Consultation and Collaboration

The applicant and Harbour Energy (or prior to 31/3/21, Premier Oil) have been in constructive discussions since 2019 concerning how to manage the impact of their respective operations upon one another. There is a large measure of agreement and both parties are hopeful that agreements will be reached that will negate the need for the imposition by the Secretary of State of Protective Provisions. Harbour Energy is committed to successful coexistence with other users of the sea/seabed.

Proposed Protective Provisions

G7.13
Ver. A

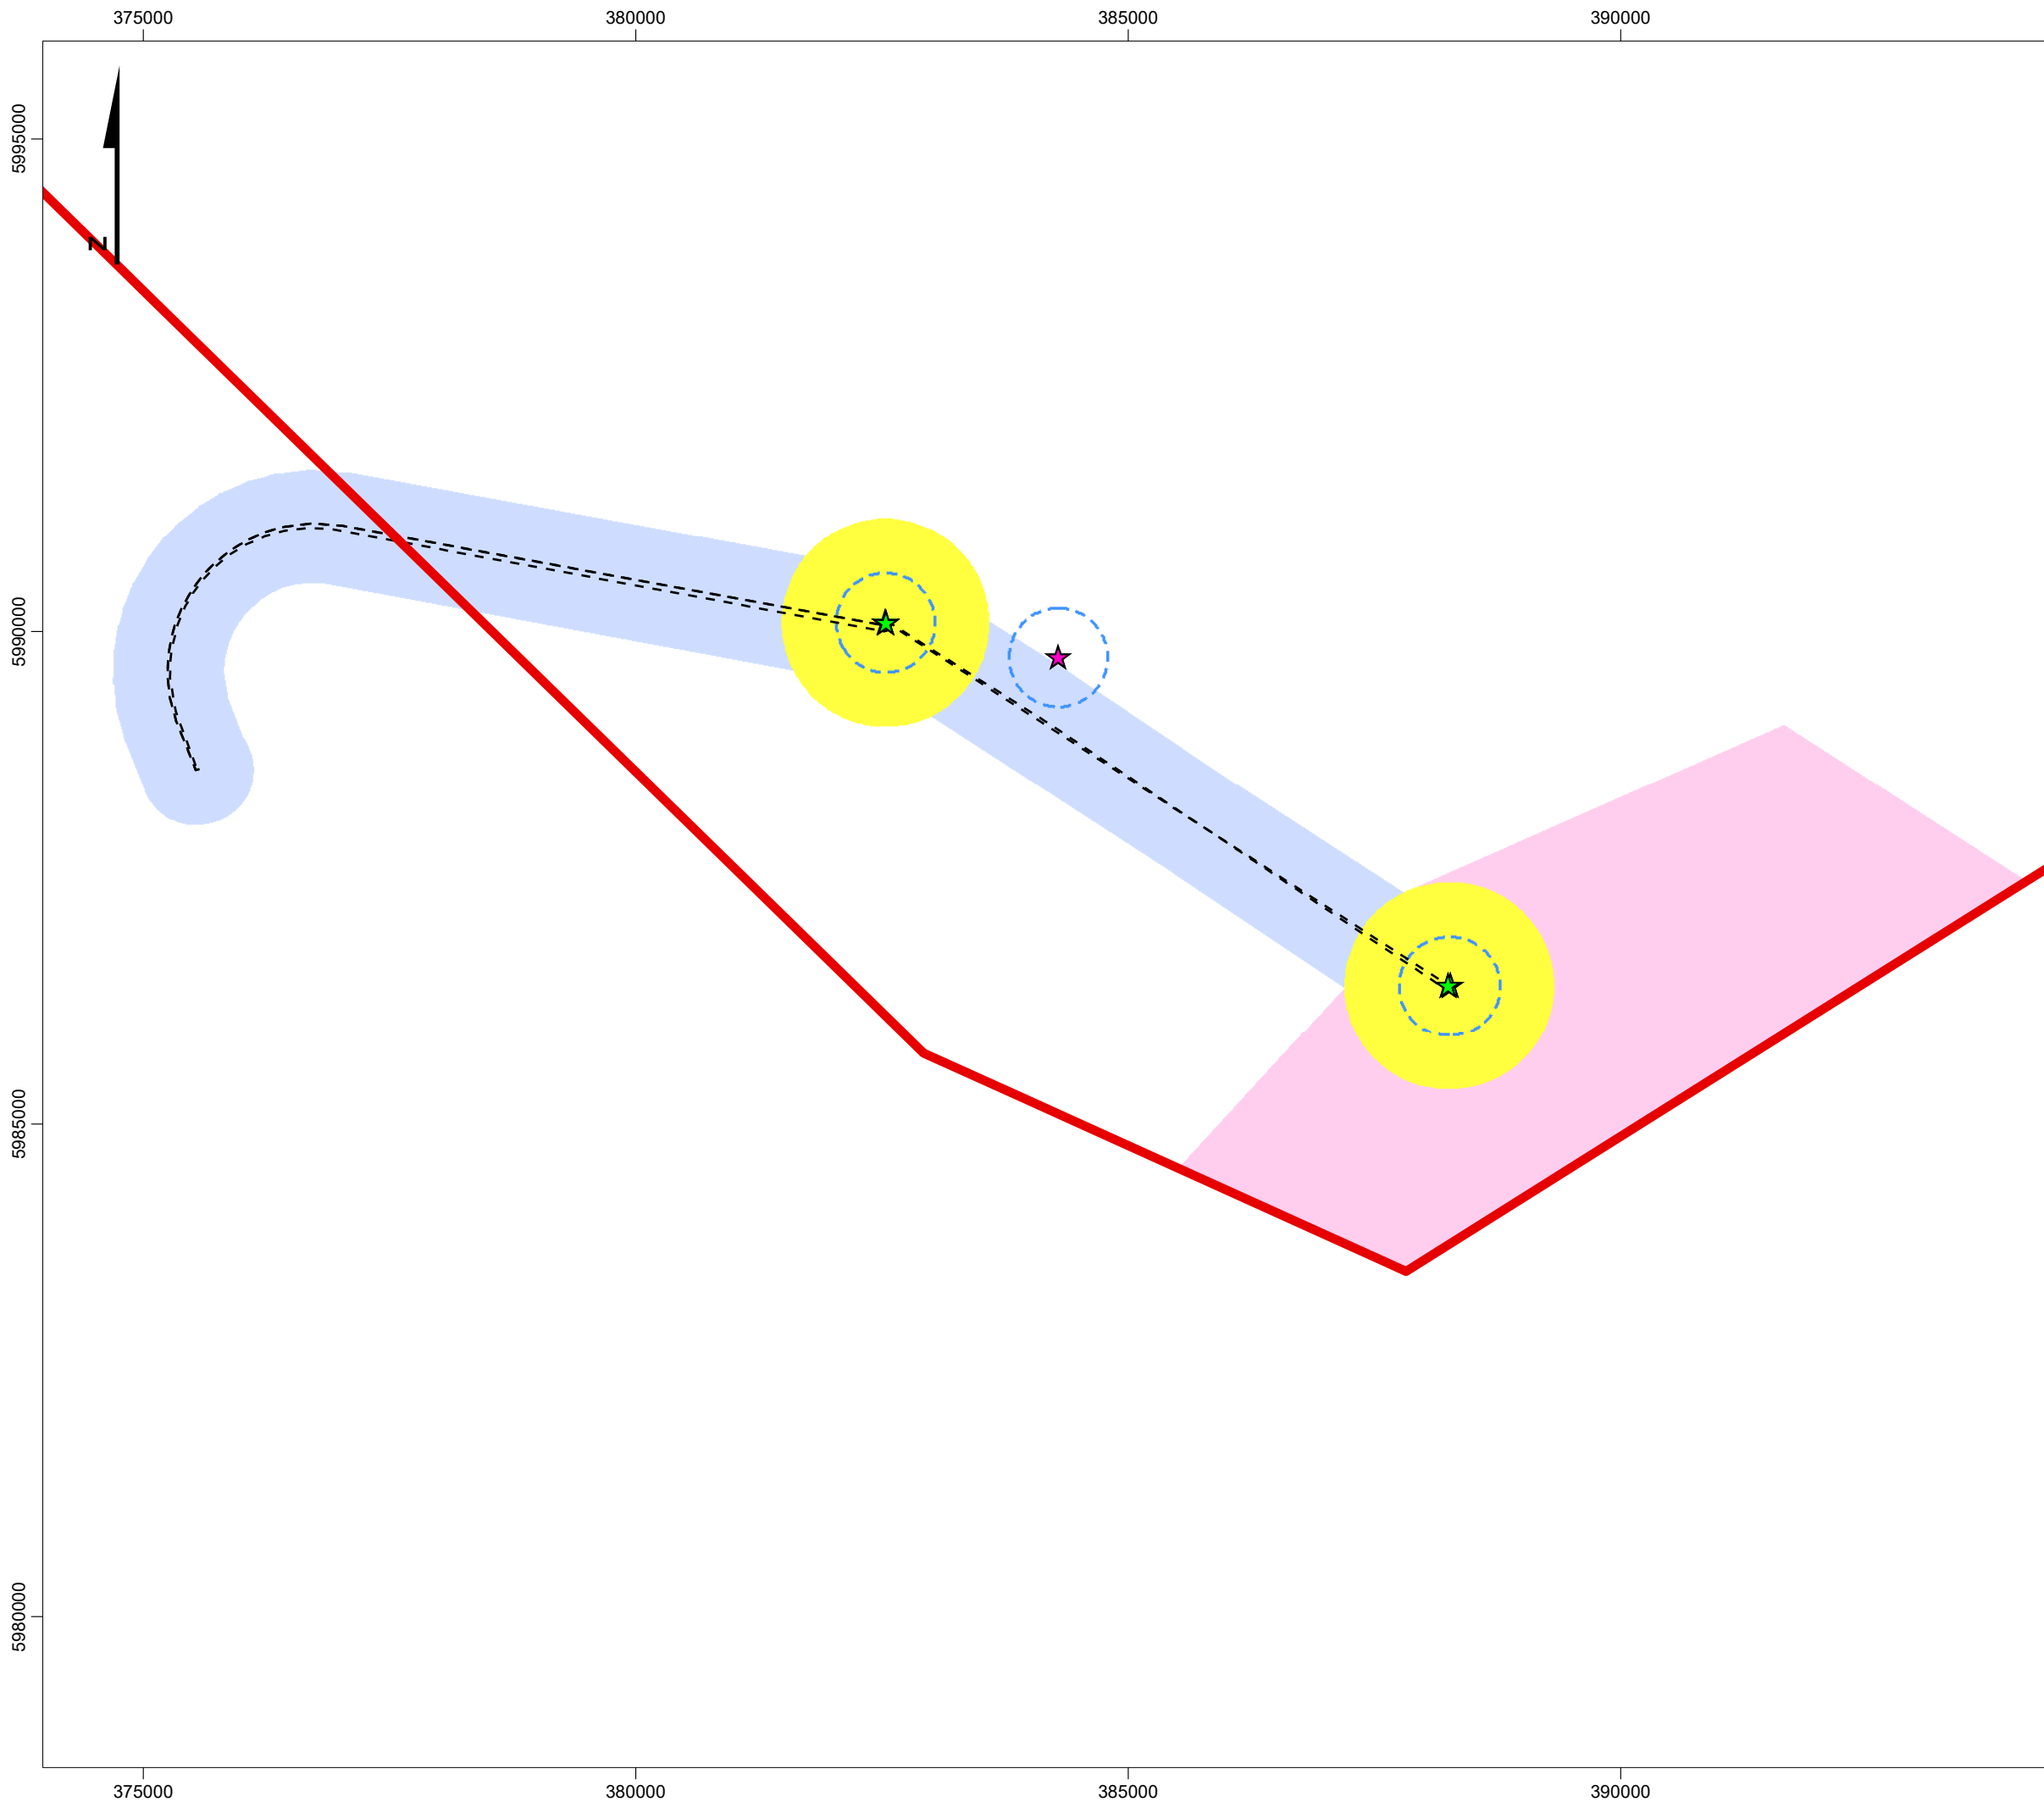
In order to enable marine and aviation access to support Johnston production and decommissioning activities, Harbour Energy propose that protective provisions are imposed that provide for:

- a 1000m wide marine corridor along the route of the pipeline which shall be free from surface obstructions;
- a 1000m wide aviation corridor providing clear airspace (free of turbines and incursion by rotors) along the pipeline route between the Johnston wellheads;
- two 1000m wide aviation corridors providing clear airspace (free of turbines and incursion by rotors):
 - from the westernmost Johnstone subsea well to the edge of the array to the SW or W; and
 - from the easternmost Johnstone subsea well to the edge of the array to the S or E.
- an area of clear airspace (free of turbines and incursion by rotors) of radius 3nm around each of the two Johnston wellheads.

These Protective Provisions are shown illustratively below:
